Case Officer: Chris Wentworth

Recommendation: Approve

Applicant: Orbit Homes (2022) Ltd

Proposal: Discharge of Conditions 5 (ground levels and finished floor levels), 12 (Construction Traffic Management Plan), 13 (Travel Information Pack), 17 (Sustainability/Energy Statement) of 21/03644/OUT

Proposed Layout and Logistics of Build Figure 2: Extract Site Compound and site Traffic Management Plan

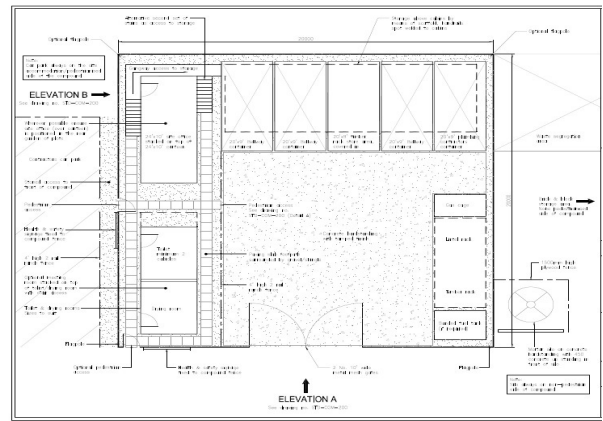
- Statement and Tree Protection Plan setting out all tree protection measures will be required to be agreed before works commence.
- The location of the tree protection fencing shown on the Proposed Layout and Logistics of Build Figure 2: Extract Site Compound and site Traffic Management Plan found on page 6 and the Construction Traffic & Environmental Management Plan on page 15, is not acceptable from an arboricultural perspective and is contrary to BS 5837:2012. It does not protect the RPAs of trees to be retained and would lead to adverse impacts to trees to be retained. As set out above, an Arboricultural Method Statement and Tree Protection Plan in accordance with BS 5837:2012, to be completed by an arboriculturist, is required.

- 5.9. The Officer goes on to state that the location of the tree protection fencing shown on the Proposed Layout and Logistics of Build Figure 2, are not acceptable from an arboricultural perspective and is contrary to BS 5837:2012 as it does not protect the RPAs of trees to be retained and would lead to adverse impacts to trees to be retained. The applicant has indicated that this will be addressed but that the location of the fencing is restricted by the boundary and the developable area therefore while some improvement might be possible, this is not likely to be significant.
